12th March 2021

Application No: A/11/21/HH
Site Address: Waterton House Arundel Road Angmering BN16 4JR
Description of works: Minor exterior and interior alterations to Listed property including 3 x new windows, back elevation, demolition of an interior dividing wall & other minor works. This application affect the character & appearance of the Angmering Conservation Area.

Thank you for your internet representation made on 11th March 2021 which has been recorded as no objection with the comments as follows:

NEW WINDOWS REF W1 and W2

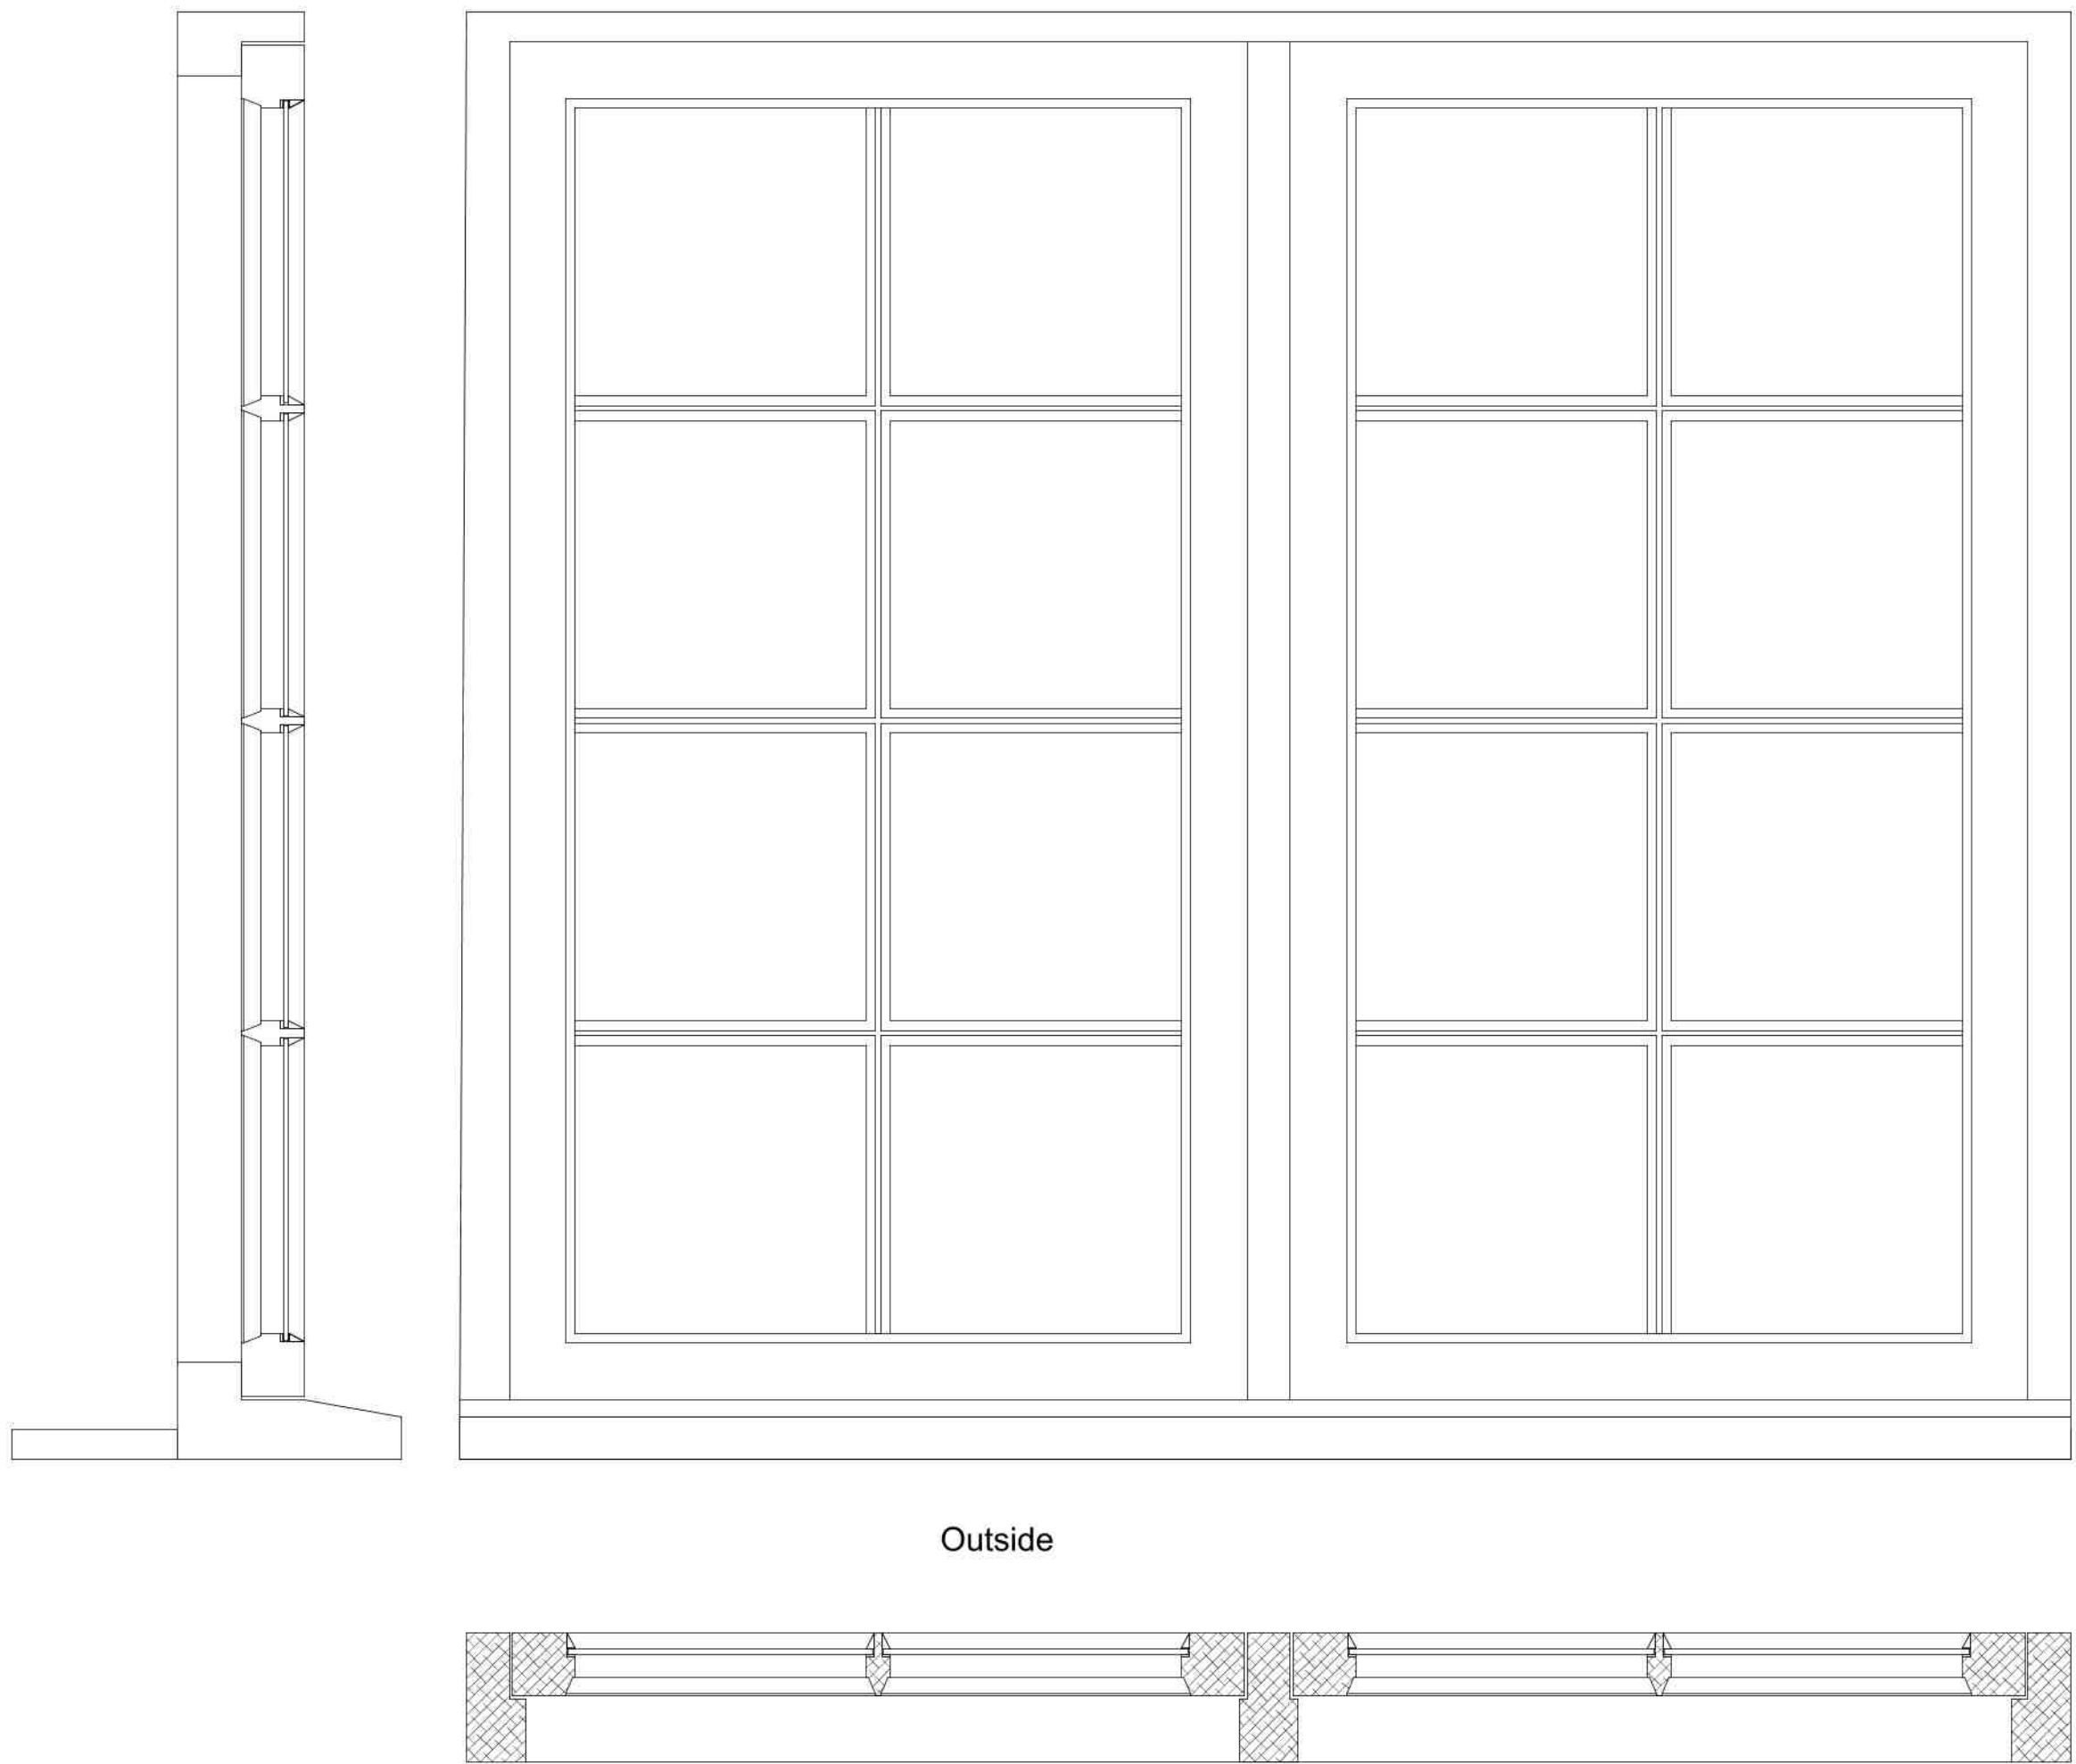
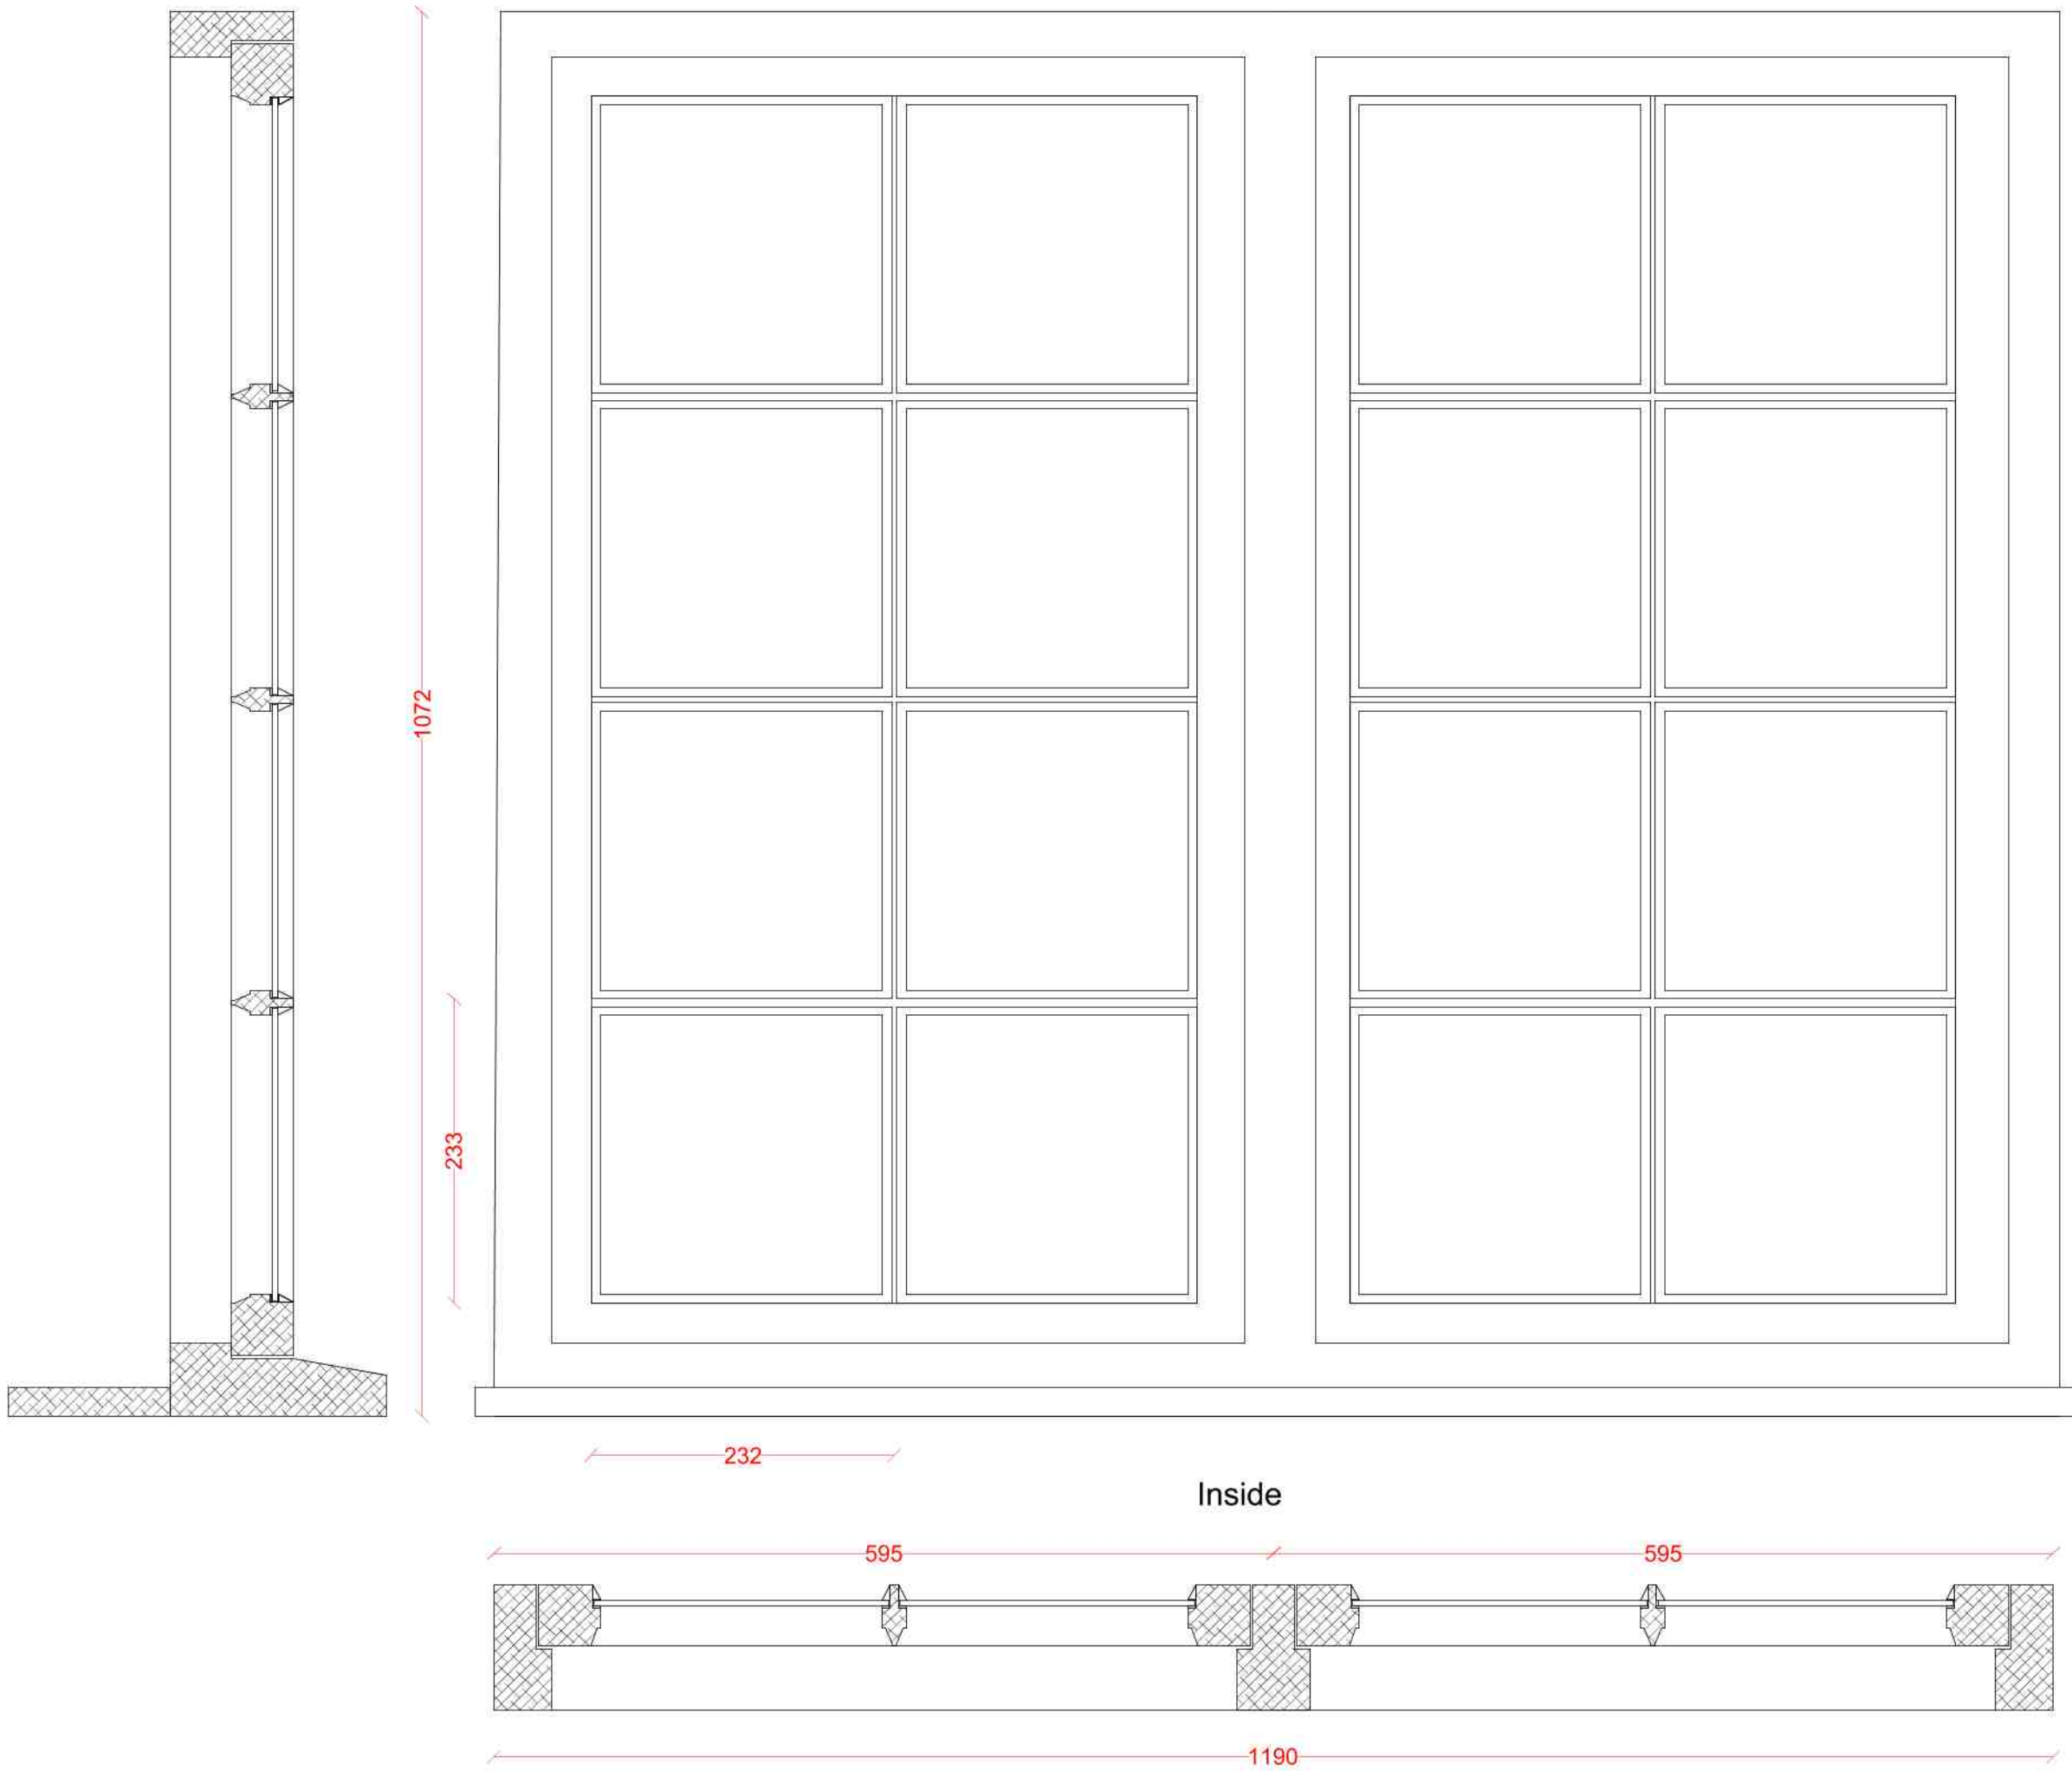
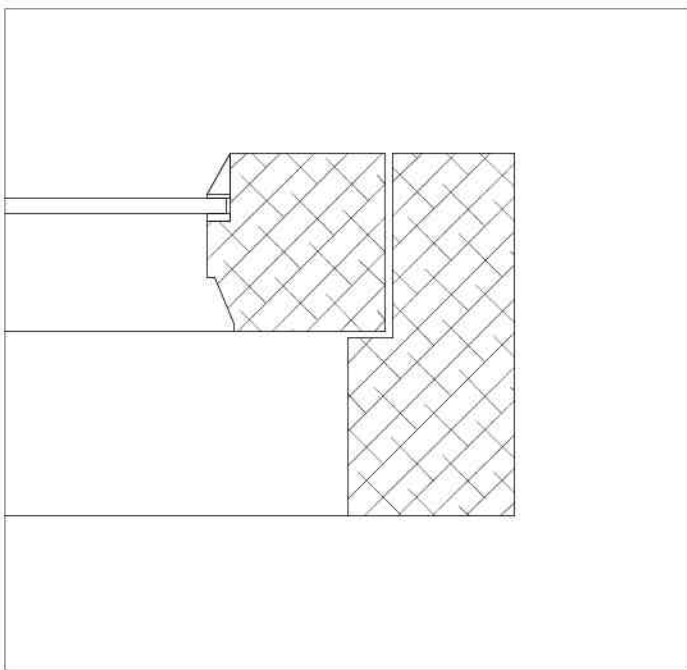
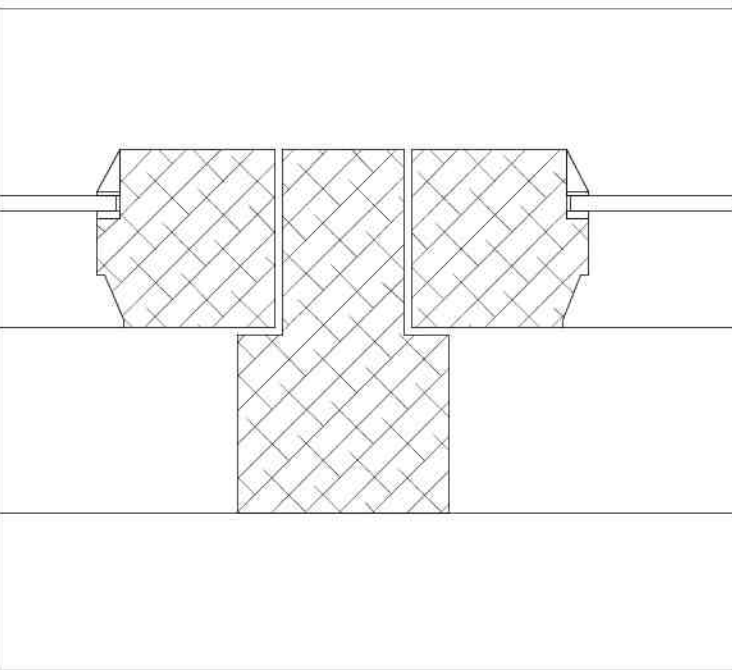
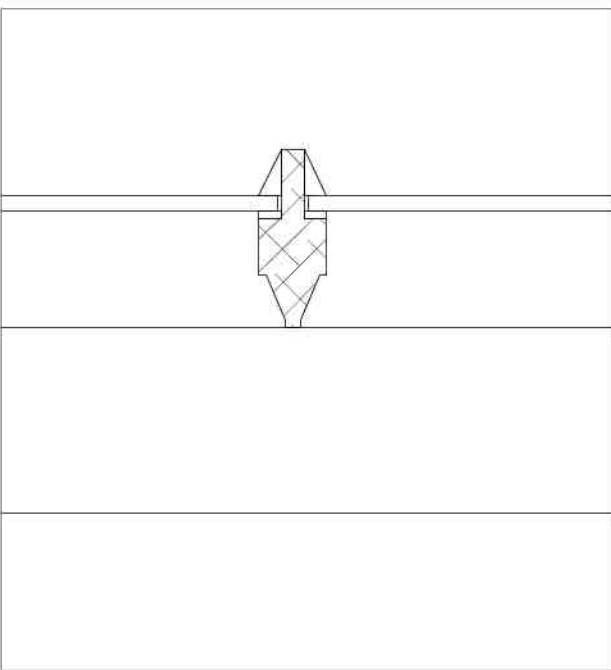
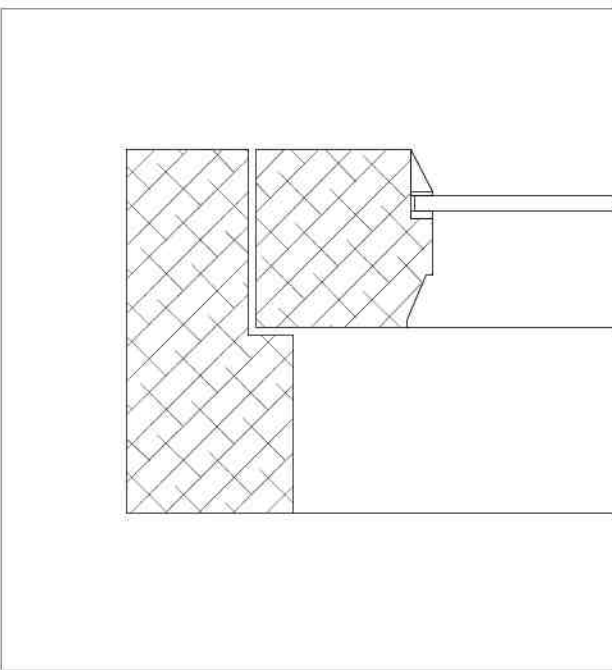
Would like the windows to be wooden
